**REGIMENT STUDENT ACCOMMODATION
& MIXED USE REDEVELOPMENT – SSD-7417**

City of Sydney Council – Consultation Meeting

MEETING MINUTES

16th January 2017 3pm

Level 1 (Street Level)

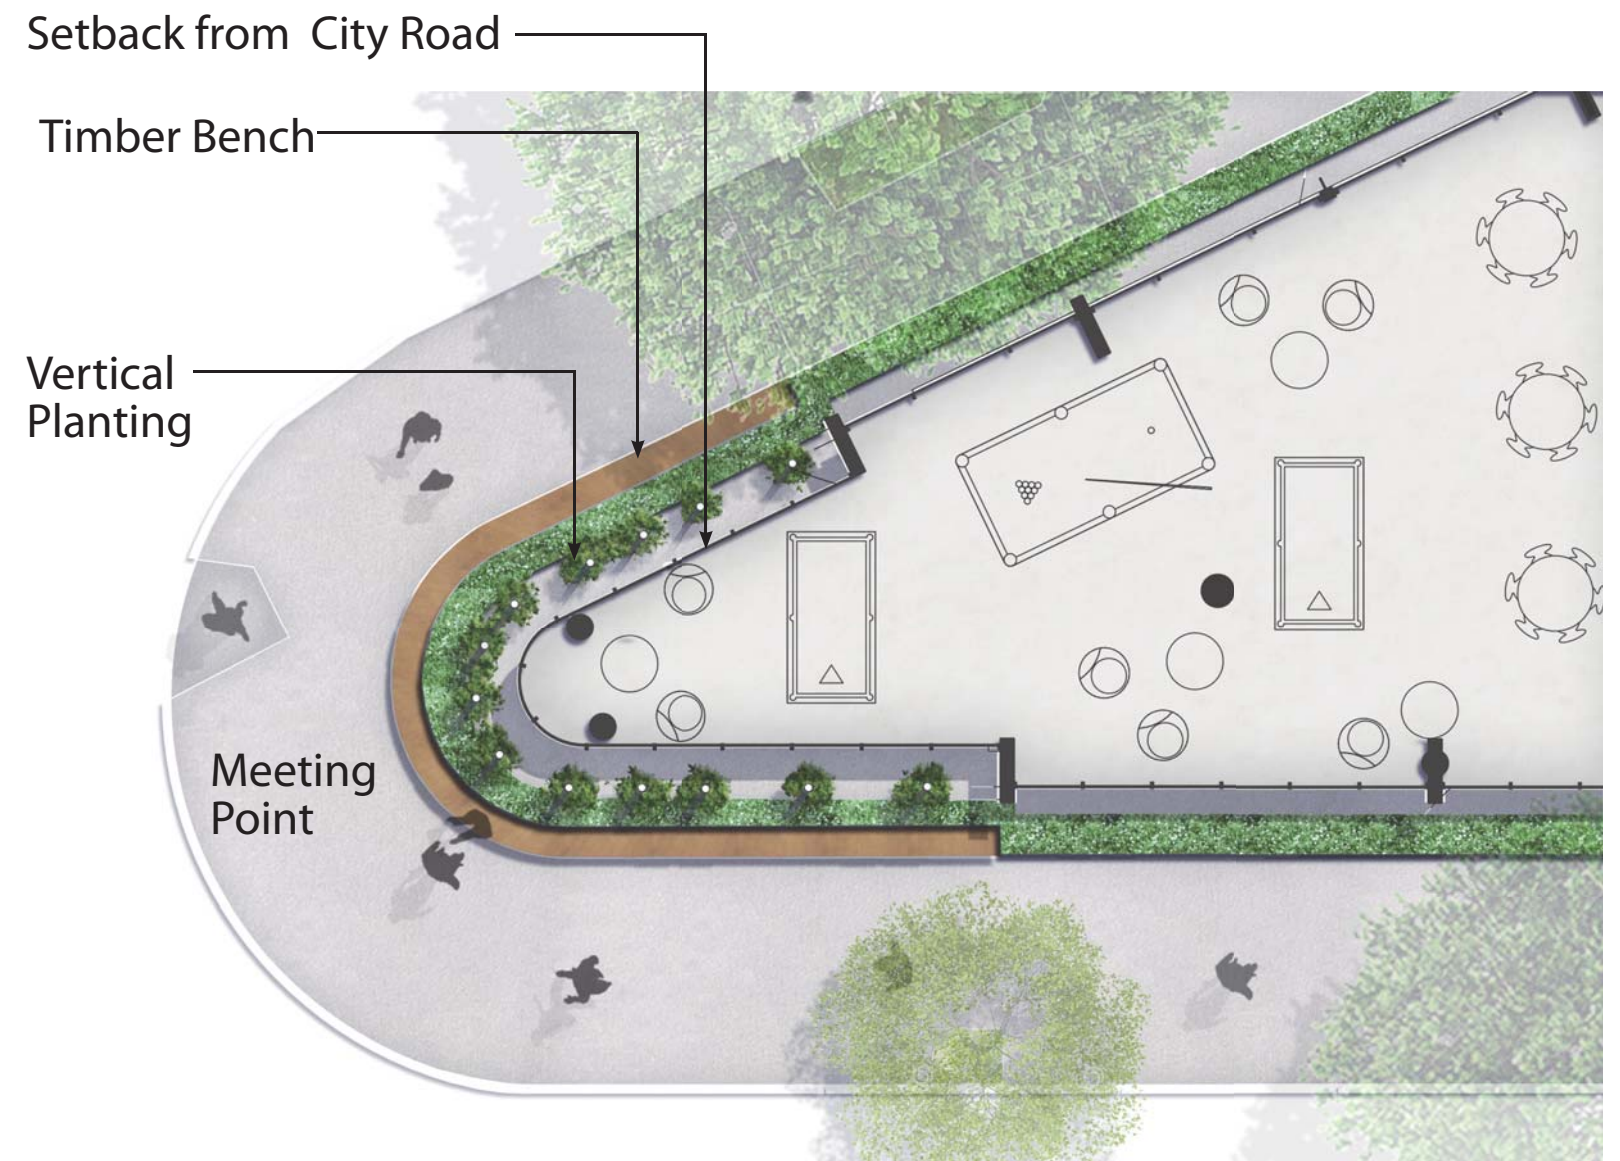
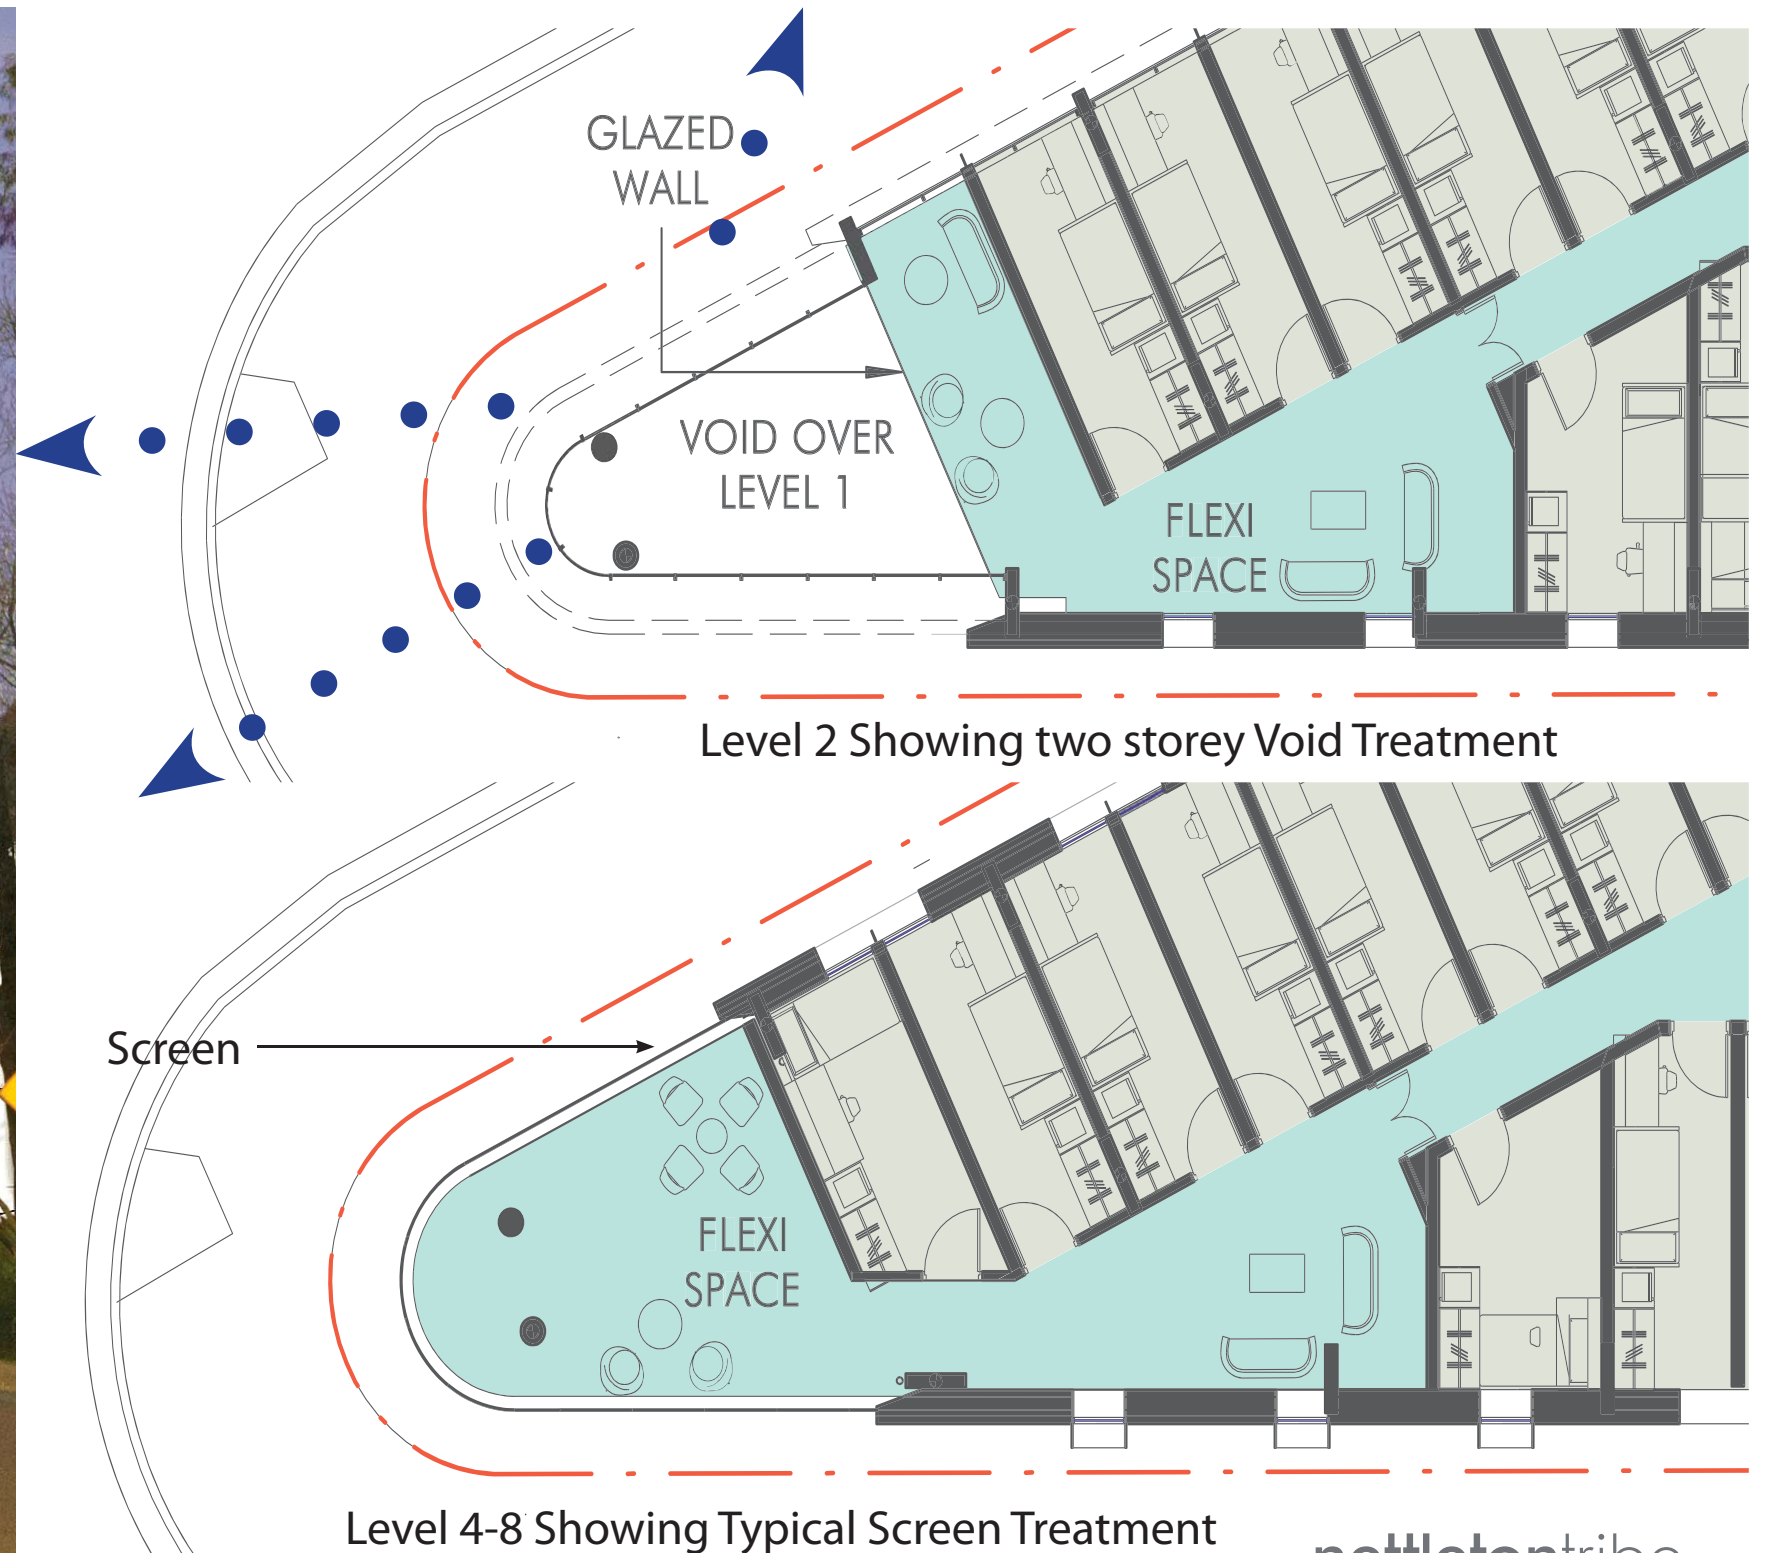
- UoS is to explore options of landscape softening to the corner façade.
